RE: Geotechnical Addendum – Response to Comments

Proposed Residence
6922 SE 33rd Street
Mercer Island, Washington

DRAINAGE & EROSION CONTROL PLAN

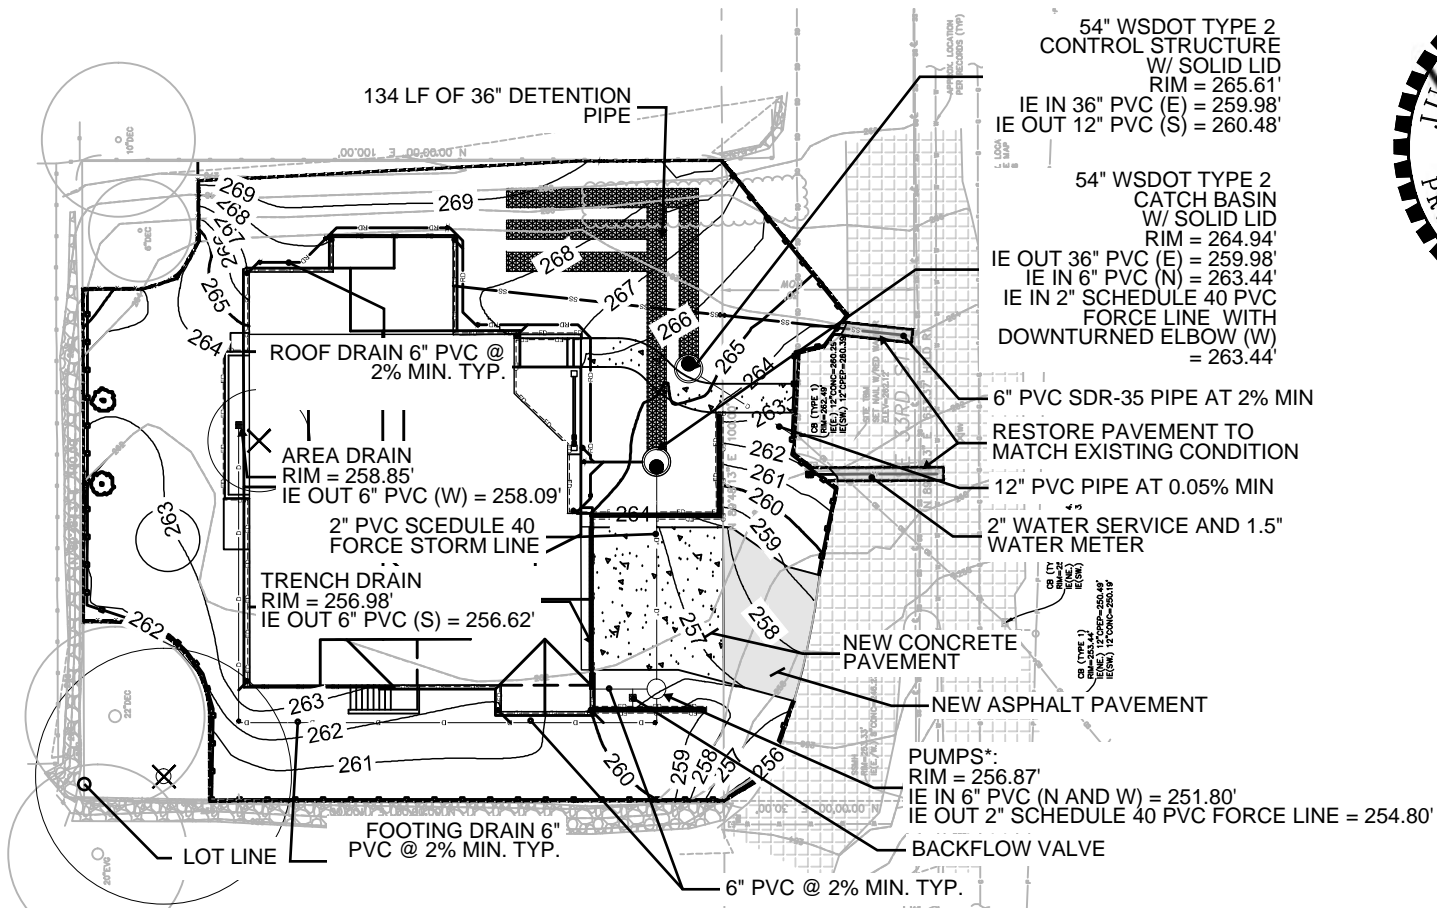
Comment: Discuss review of the updated plans dated October 19, 2022.

Response: We have reviewed the updated plans and have no comments at this time.
